Approval of details reserved by Condition 14 (bay studies) - 49-53 Glengall Road, SE15 6NF

On behalf of Southern Home Ownership Limited, I hereby submit an application in accordance with the Town and Country Planning Act 1990 for the approval of details reserved by Condition 14 of planning permission 17/AP/4612 and the non-material amendments granted under 20/AP/3555.

Condition 14 was fully discharged on 10 August 2023 under application reference 21/AP/2774. However, there are some design and buildability issues with the approved commercial façades that need to be amended:

client name	HG Construction
project	49 - 53 Gleggall Road
drawing	Bay detail 03
computer file	2020.000475.000
project number	2020.000475.000
drawing name	GLE-AHR-ZZ-ZZ-DR-A-20903
date	27.11.2023
scale	As indicated@A0
revision	C2 S1

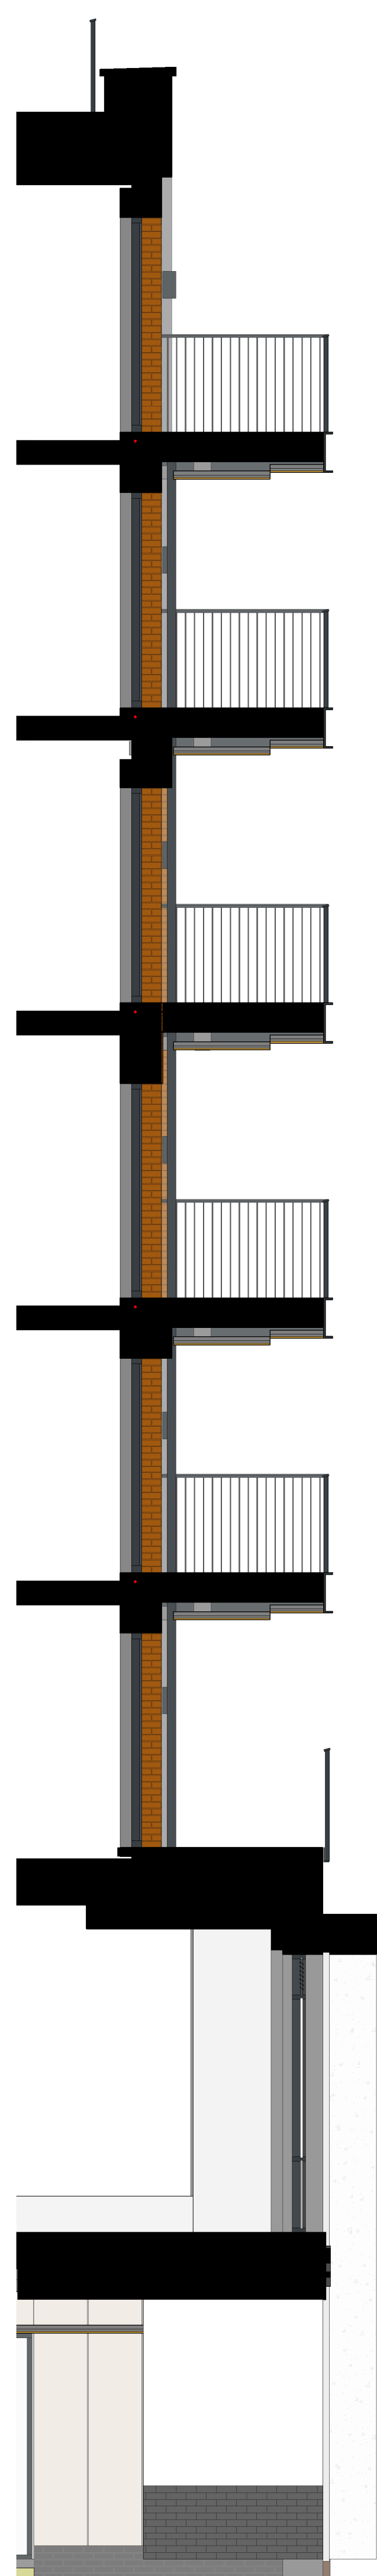
- The fins do not align with the curtain walling behind and therefore to maintain the glazing it would be necessary to disassemble the fins which would be a very difficult and expensive exercise that would require an increase to the commercial service charge.
- The fins as drawn cannot be constructed as per the design intent. There would need to be substantial beams and bracing, as well as thickening of the fins themselves, to enable them to be supported and not flex or cause noise due to reverberation from the wind and other environmental conditions.

In short, it is proposed that the fins are omitted, whilst maintaining the Core-Ten picture framing to the openings. This is roughly demonstrated on the example images below:

- **Bay Detail 01 (ref. GLE-AHR-ZZ-ZZ-DR-A-20901 Rev C2)**
- Bay Detail 02 (ref. GLE-AHR-B1-ZZ-DR-A-20902 Rev C2)
- **Bay Detail 03 (ref. GLE-AHR-ZZ-ZZ-DR-A-20903 Rev C2)**
- **Bay Detail 04 (ref. GLE-AHR-ZZ-ZZ-DR-A-20904 Rev C2)**
- **Bay Detail 05 (ref. GLE-AHR-ZZ-ZZ-DR-A-20905 Rev C2)**
- **Bay Detail 06 (ref. GLE-AHR-ZZ-ZZ-DR-A-20906 Rev C2)**
- **Bay Detail 07 (ref. GLE-AHR-ZZ-ZZ-DR-A-20907 Rev C2)**
- **Bay Detail 08 (ref. GLE-AHR-ZZ-ZZ-DR-A-20908 Rev C3)**
- **Bay Detail 09 (ref. GLE-AHR-ZZ-ZZ-DR-A-20909 Rev C3)**
- **Bay Detail 10 (ref. GLE-AHR-ZZ-ZZ-DR-A-20910 Rev C2)**
- Bay Detail 11 (ref. GLE-AHR-ZZ-ZZ-DR-A-20911 Rev C1)
- **Bay Detail 12 (ref. GLE-AHR-ZZ-ZZ-DR-A-20912 Rev C3)**
- Bay Detail 13 (ref. GLE-AHR-ZZ-ZZ-DR-A-20913 Rev C1)
